**Consultation Response from KC,
Lead Local Flood Authority**

2024/92235 Land off, Blackmoorfoot Road and Felks Street, Crosland Moor, Huddersfield, HD4 7AD

Date Responded: 4th October 2024

TITLE			
FLOOD ROUTING LAYOUT SHEET 3 OF 5			
PROJECT			
BLACKMOORFOOT ROAD, HUDDERSFIELD			
CLIENT			
MILLER HOMES LTD COUNTRYSIDE HOMES LTD VISTRY HOMES LTD			
DRAWING STATUS			
PRELIMINARY			
Scale	Date	Drawn	IC
1:500 @ A1	AUG 24	Chk.	MI
Drg. No.			Rev
425/92/SK12.03			B

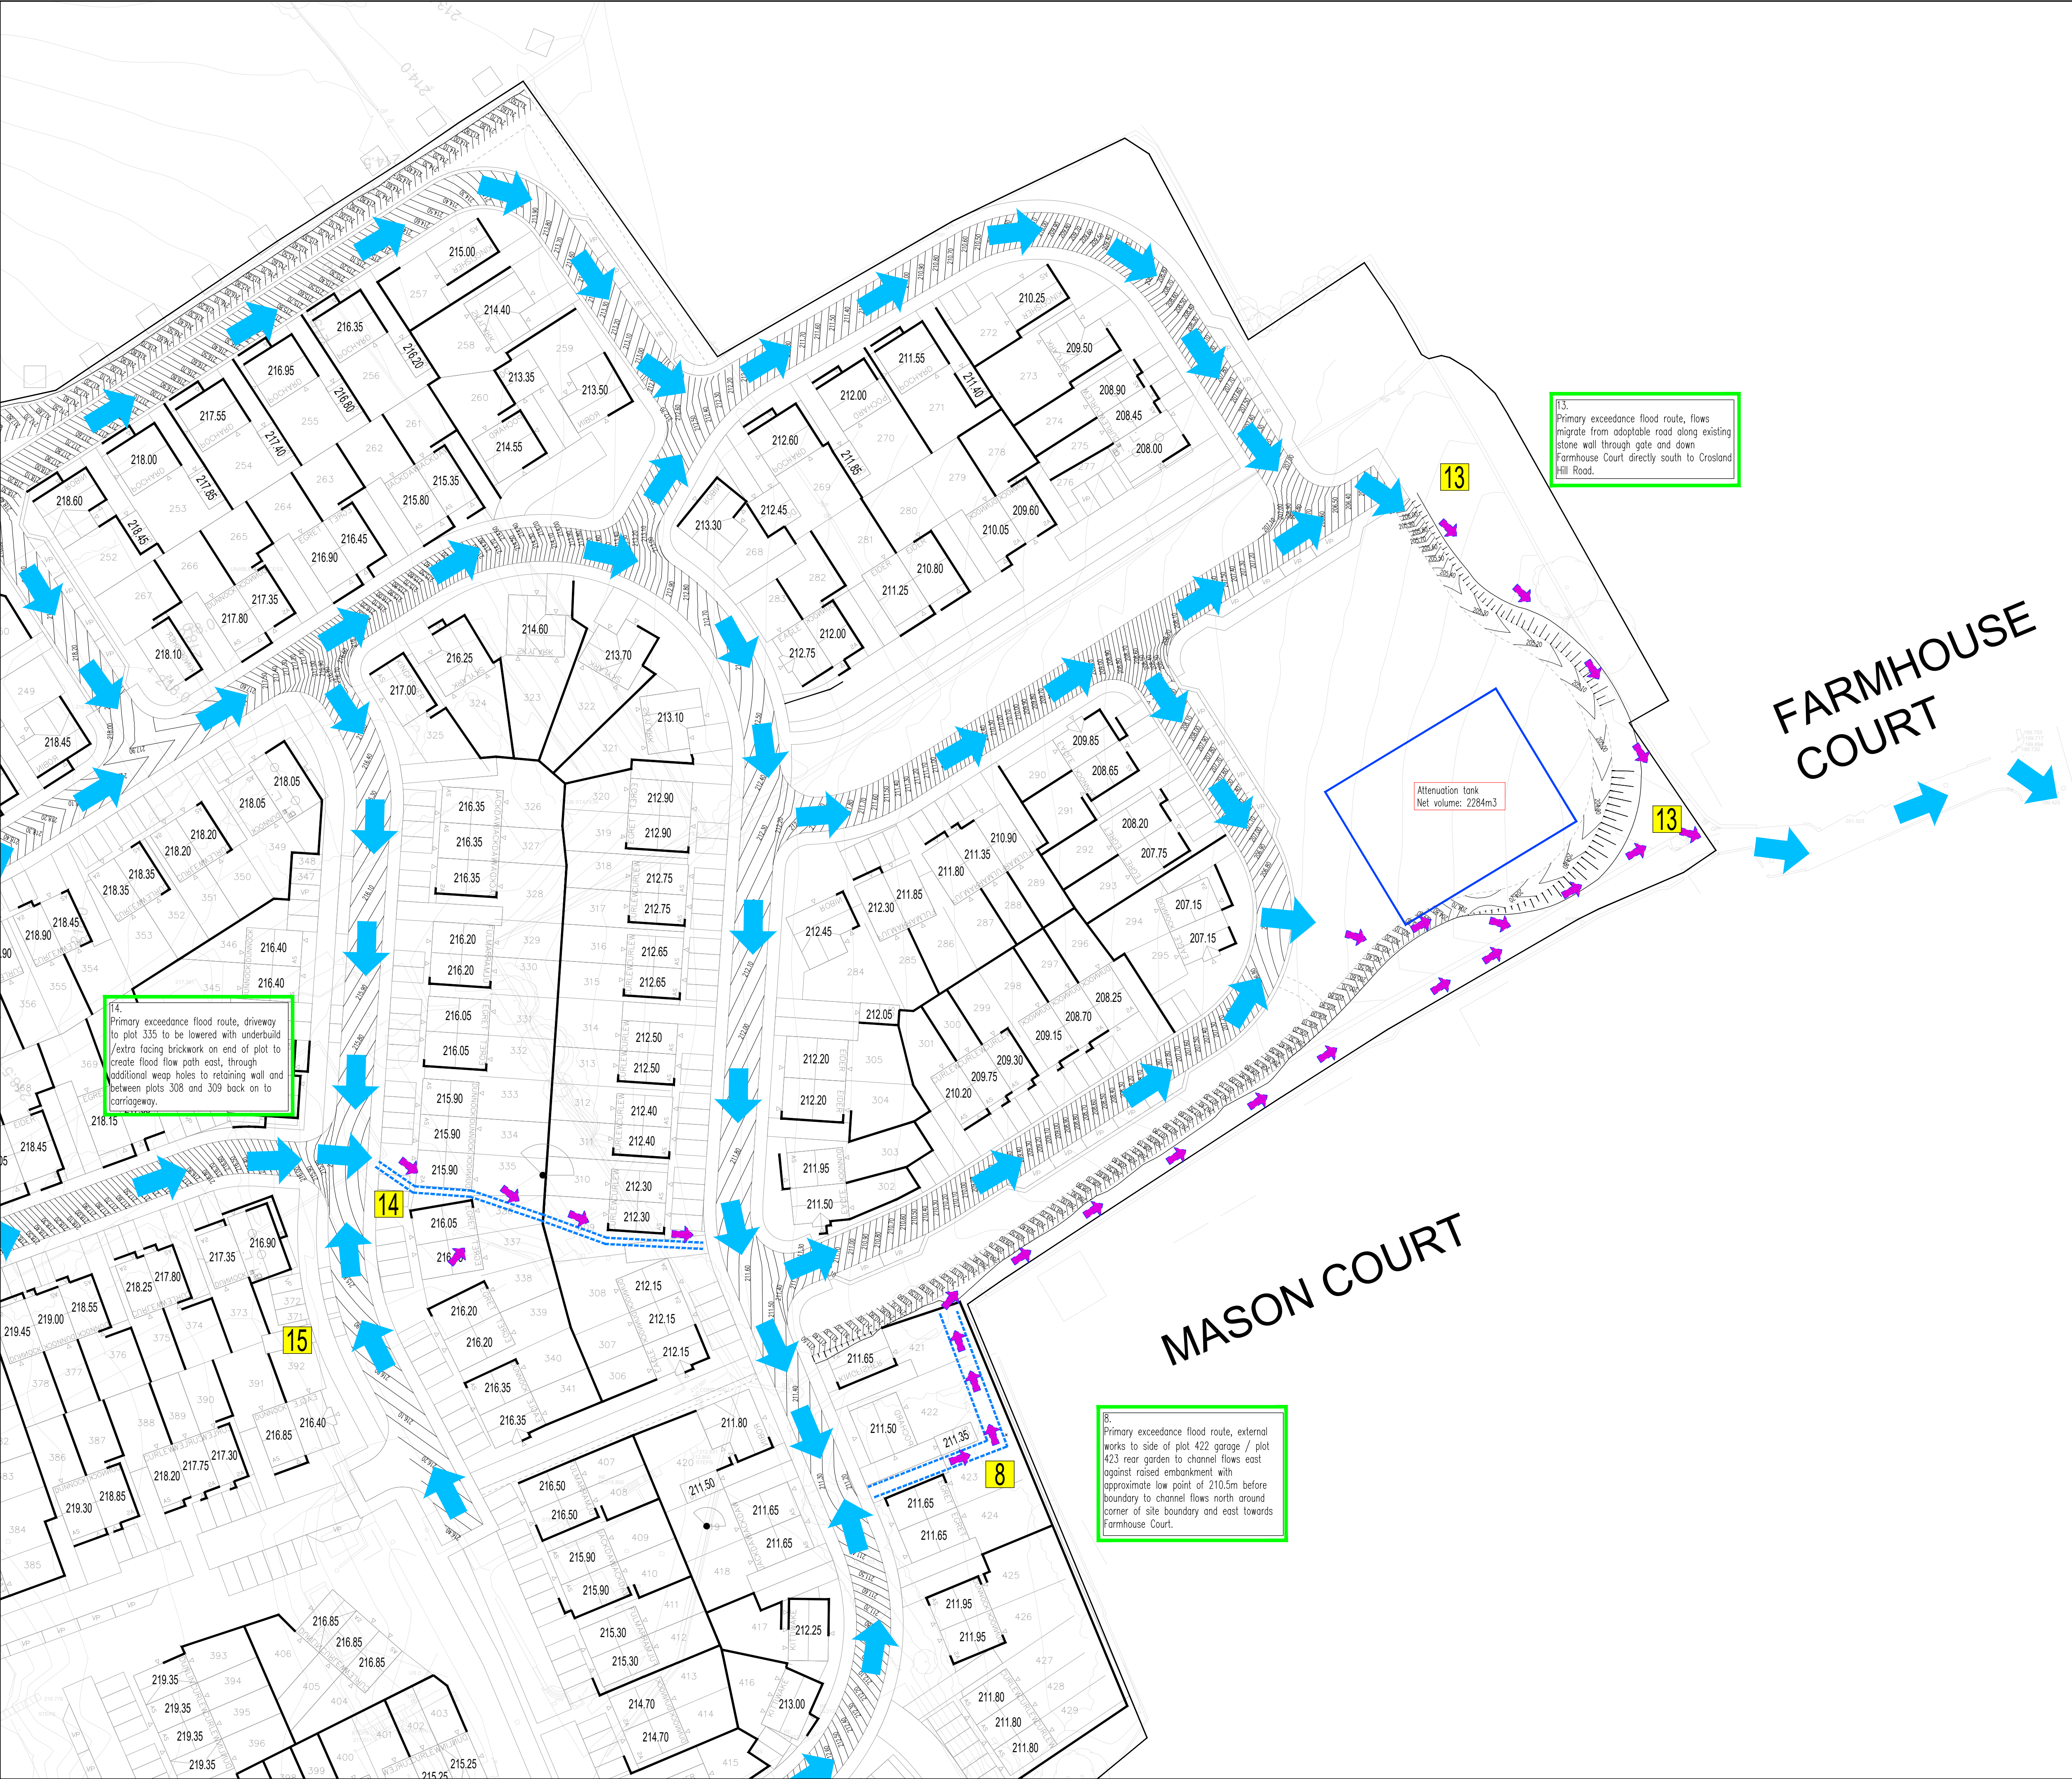
Kirklees Flood Management & Drainage acting as Lead Local Flood Authority OBJECTS to this application on the grounds of layout design promoting surface water flood risk to property.

After examining the submissions relating to flood routing, the design fails to utilise roads and open space as conduits throughout the site. The results in flood routing through curtilages in several places. This goes against first principles.

There are places where additional information with levels on private shared driveways and fall shown away from property may result in some concerns removed.

The following list are areas that need reconsideration. The applicant's consultant should check to see if this list is exhaustive. Any subsequent alterations will need to be discussed with section 38 and well as the LLFA to ensure they are satisfactory to both departments.

- Plots 215-225/6
- Plot 381
- Plot 422-423
- Plots 336/309
- Plots 445/457
- Plots 604/607
